28 March 2023

Yr Ref EN010133

Planning Act 2008 (as amended) – Section 55

Application by Cottam Solar Project Ltd for an Order Granting Development Consent for the Cottam Solar Project – Relevant Representations (Ref EN010133)

Drawing file: EN010133 / EN010133-001023-C6.4.8.16.1_A Figure 8.16.1 Landscape and Ecology Mitigation and Enhancement Plan - Cottam 1_North_Sheet 1.pdf

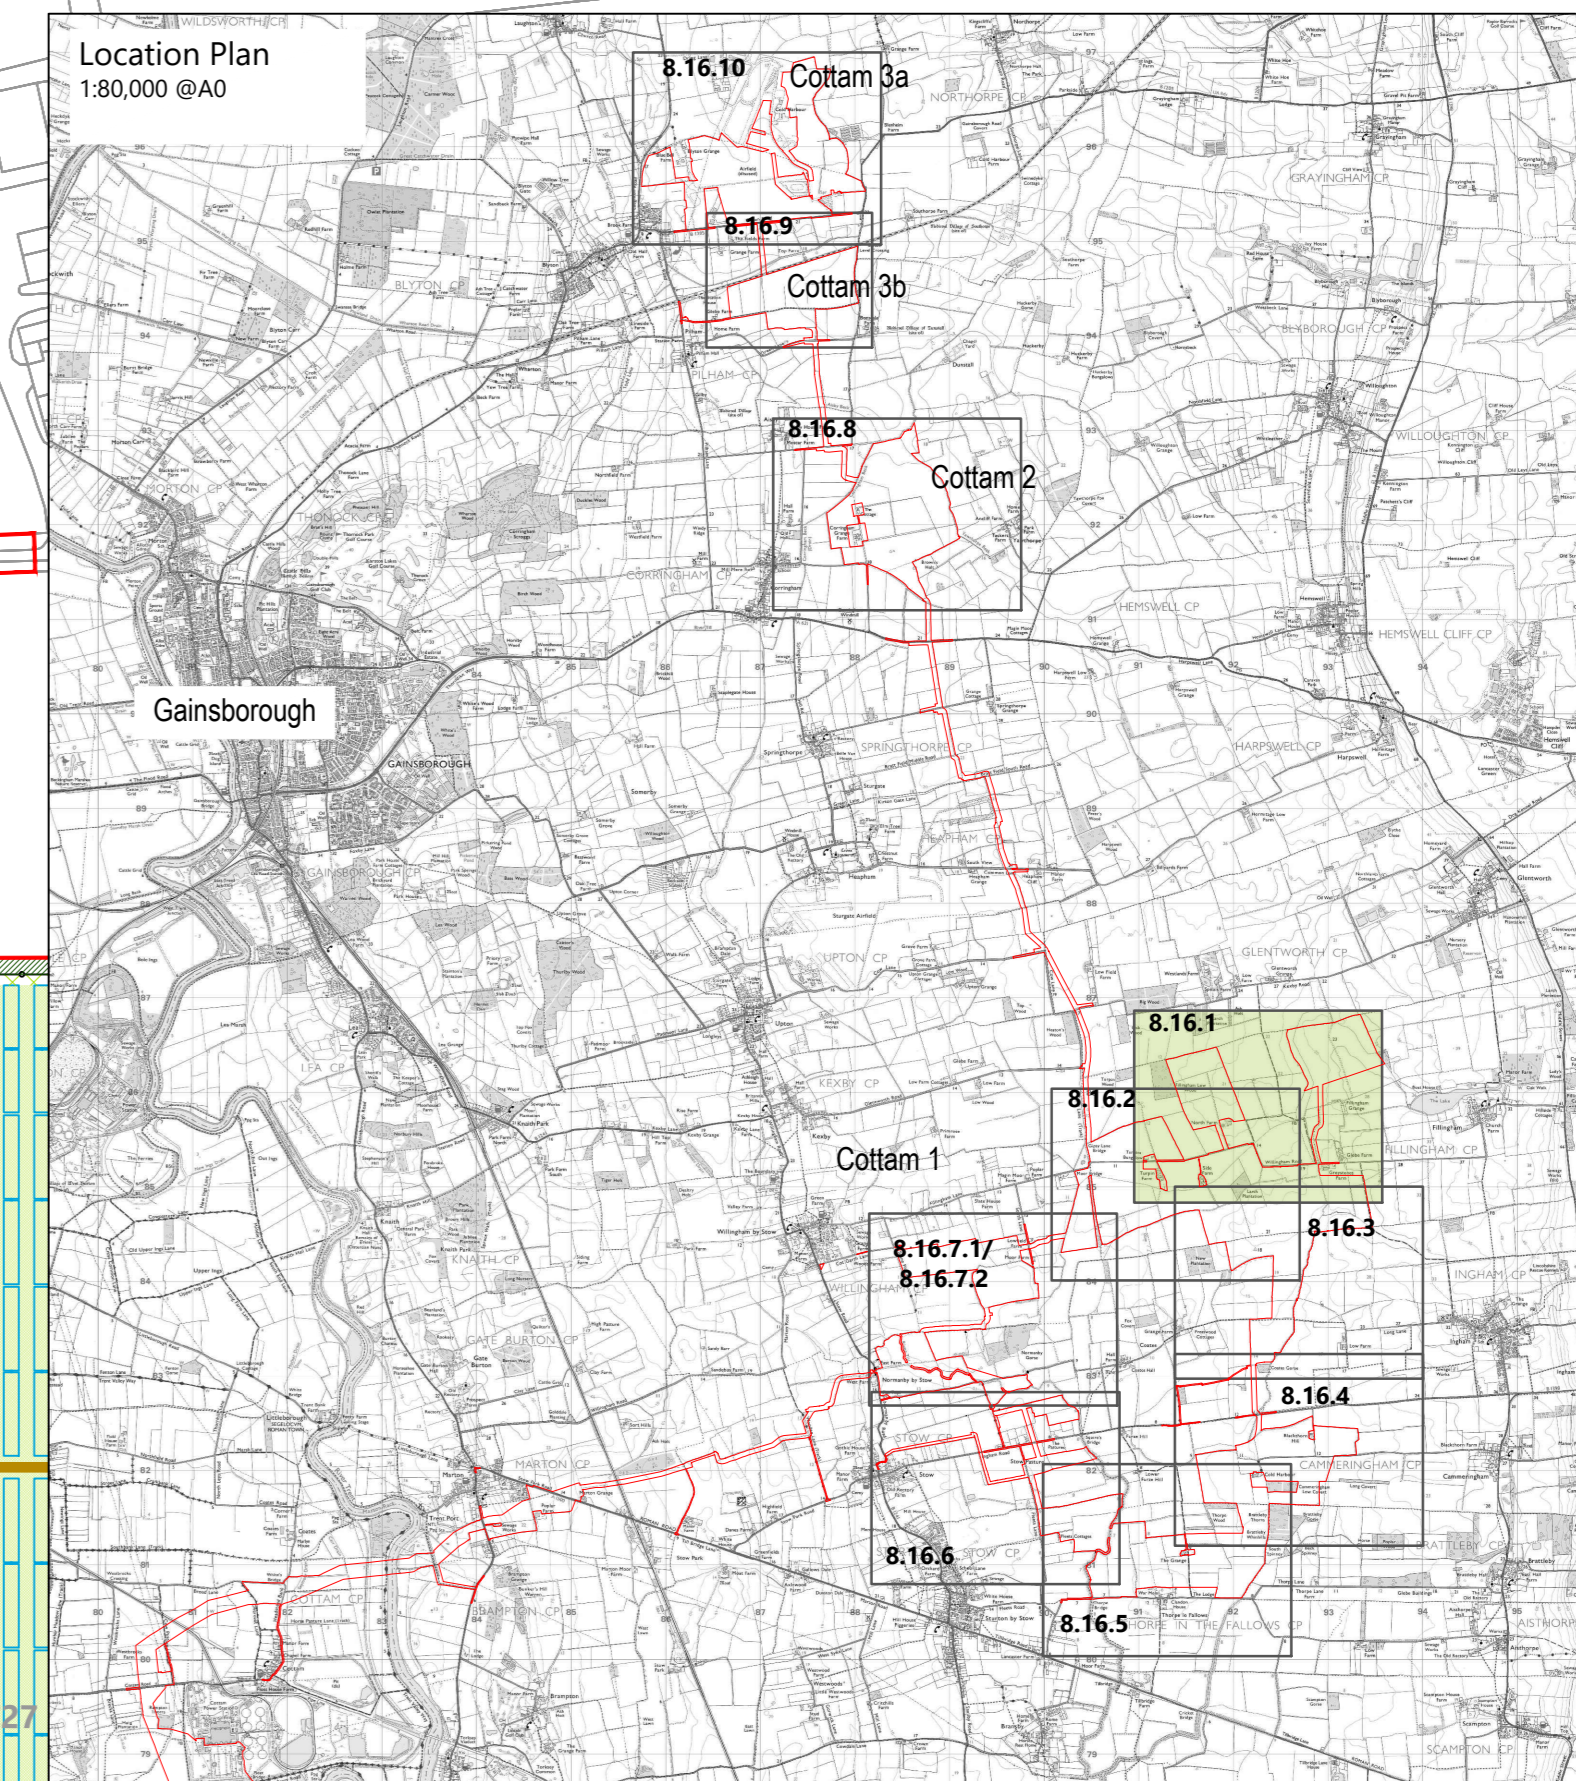
The submission has not provided sufficient information in regards to the impact upon, or protection of, existing trees, hedgerows and other important vegetation in order for comment to be made at this stage. These impacts are not limited to the solar development areas, but associated with access and highways works to facilitate the development, such as construction access, particularly from large plant, or access points and associated visibility splays,. It is unclear on the landscape and ecology plans

as to the extent of vegetation removal proposed, and the LVIA implies little or no vegetation removal is proposed. *Appendix 14.1: Transport Assessment* also identifies some localised areas of hedge removal and several instances of trimming back. The extent of this needs clarifying during the examination.

Figure 8.16.10: Landscape and Ecology Mitigation and Enhancement Plan – Cottam 3A Revision A

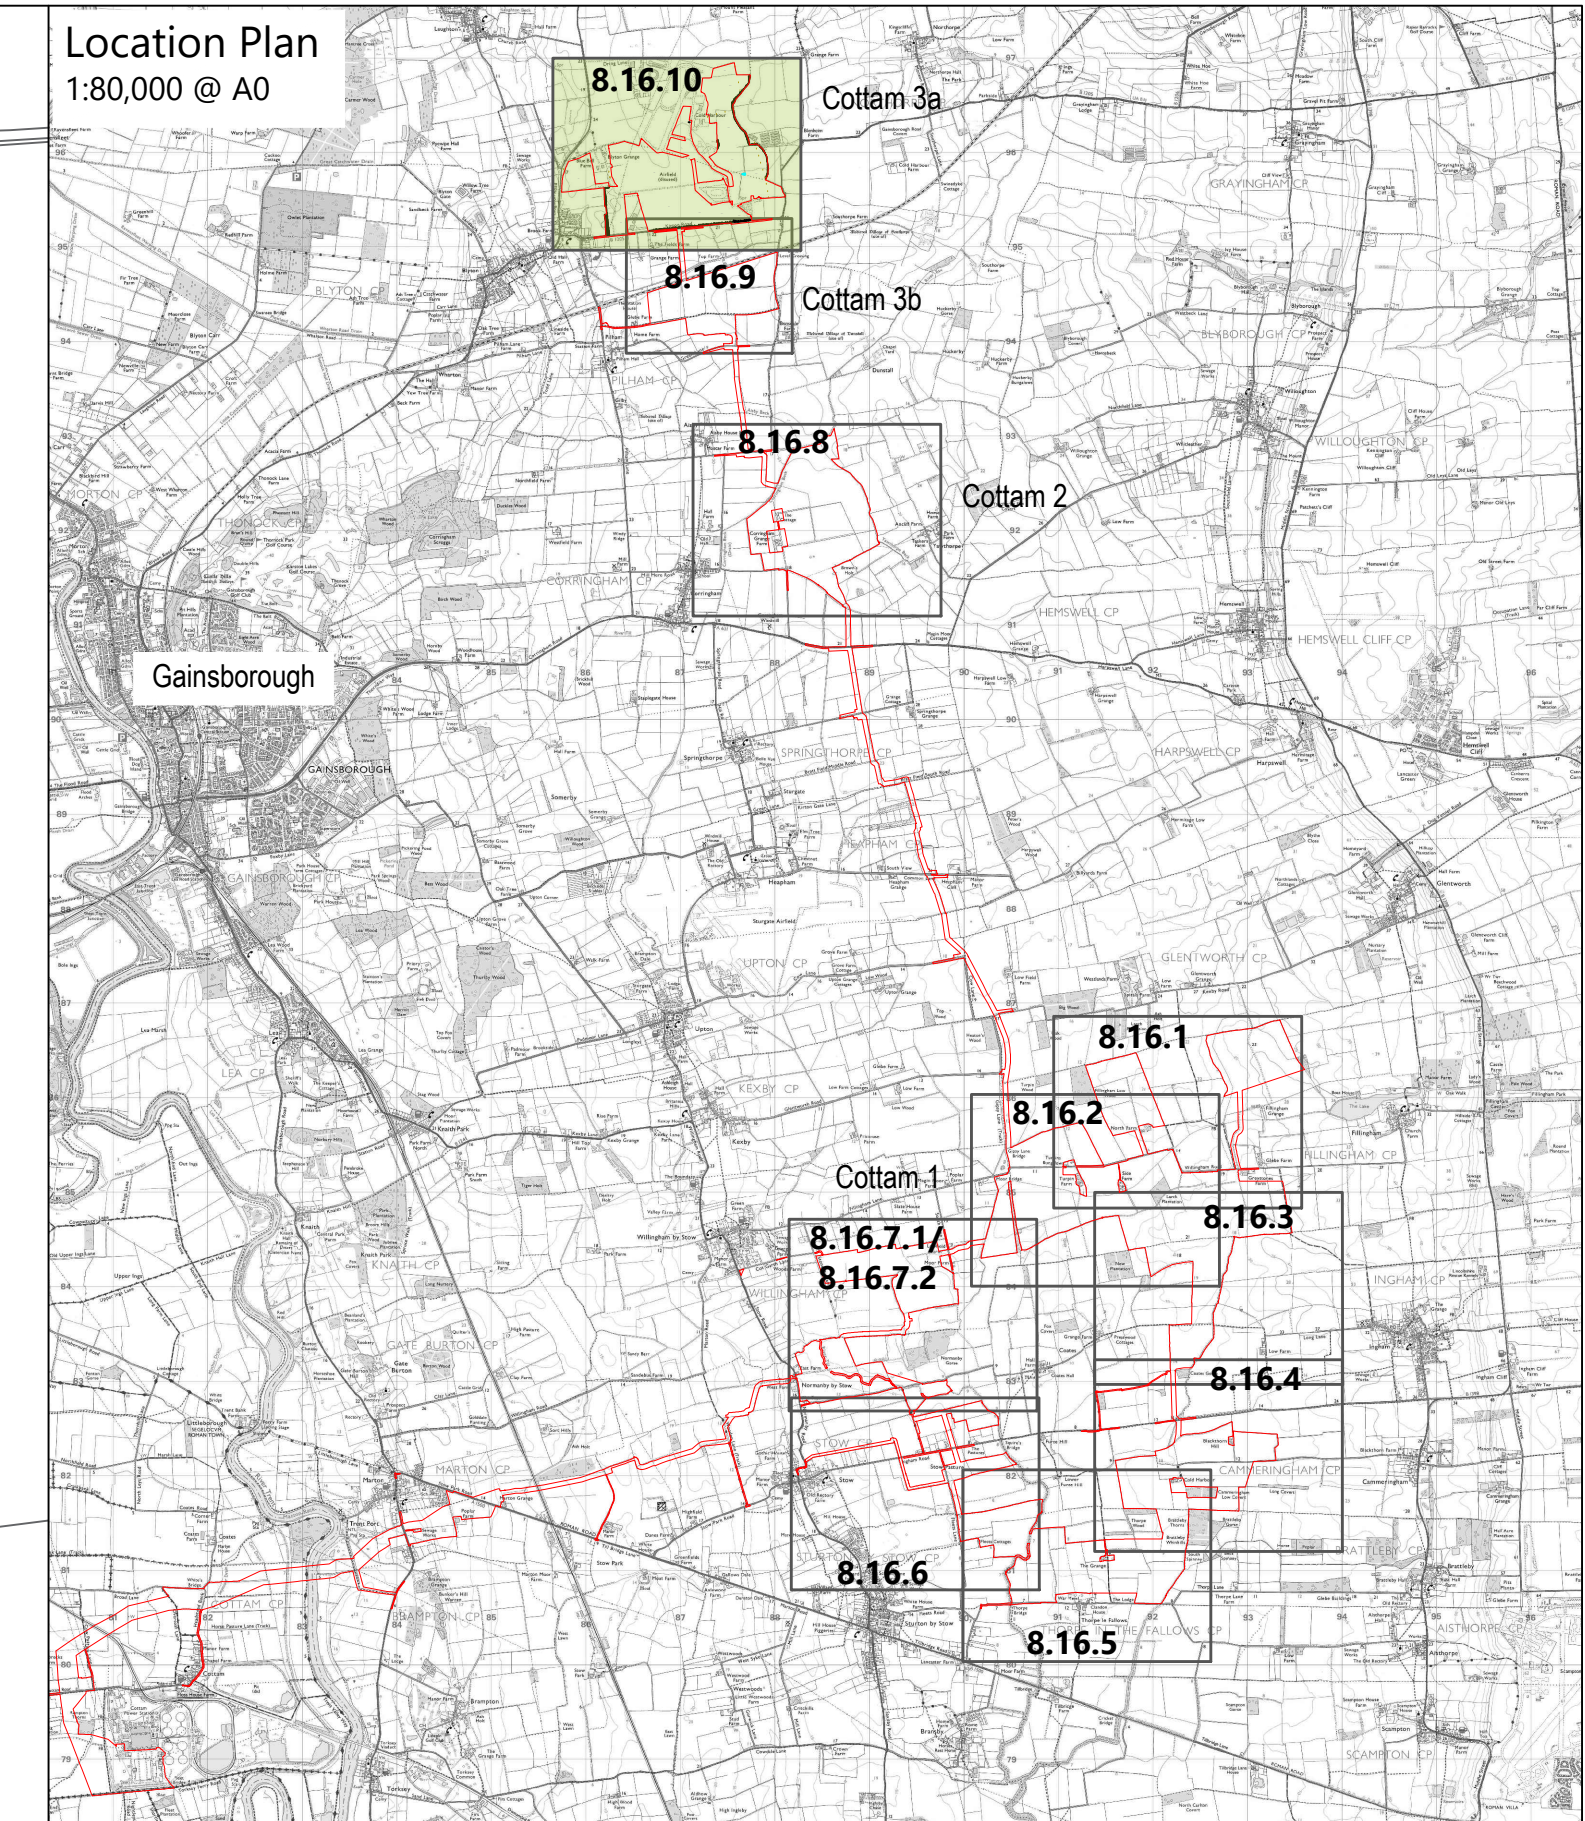
The proposal would evidently deliver landscape and ecological improvements through mitigation areas and planting. However, this will be dependent upon the information set out in the *Landscape and Ecological Management Plan Outline Plan (C7.3)* and *Landscape and Ecology Mitigation and Enhancement Plans (Figures 8.16.1 to 8.16.10)*, which should be further explored, and assume would be refined at the detailed design stages and subject to appropriate worded requirements in the DCO to capture this.
